Date: 22 October 2012

APPLICATION FOR THE PROPOSED ABLE MARINE ENERGY PARK BY ABLE HUMBER PORTS LTD

THE INFRASTRUCTURE PLANNING (EXAMINATION PROCEDURE) RULES 2010 – RULE 17 FURTHER INFORMATION

Figure 2: Indicative layout of wet grassland area

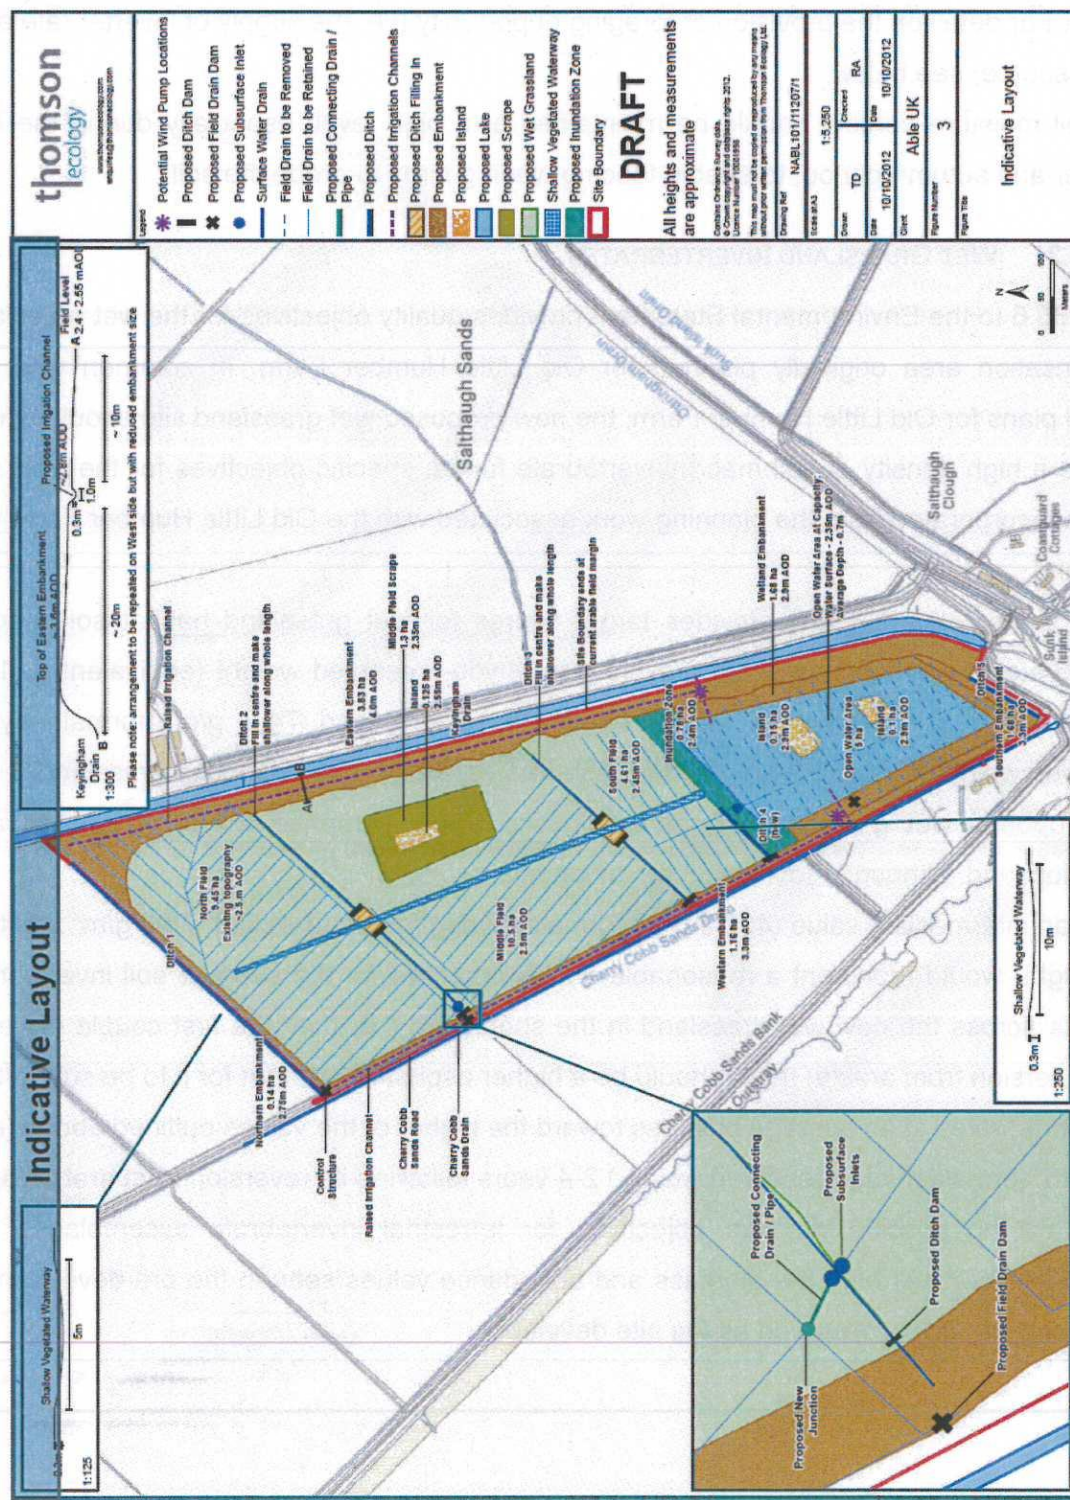
- 2) The proposal described in Part 4 of EX28.3 is for development of an area of wet grassland between the Keyingham Drain and the Cherry Cobb Sands Drain with the intention that this would be a bird roost. As part of the managed realignment at Cherry Cobb Sands it is proposed that the public footpath, currently running along the flood defence wall would be relocated in association with the realigned flood defence wall. The applicant having regard to potential disturbance of wildlife by persons on the footpath has proposed that the footpath be on the landward side of the flood defence. Does the proposal to promote use of the area of wetland as a birdroost have implications for the detailed location and/or design of this footpath?
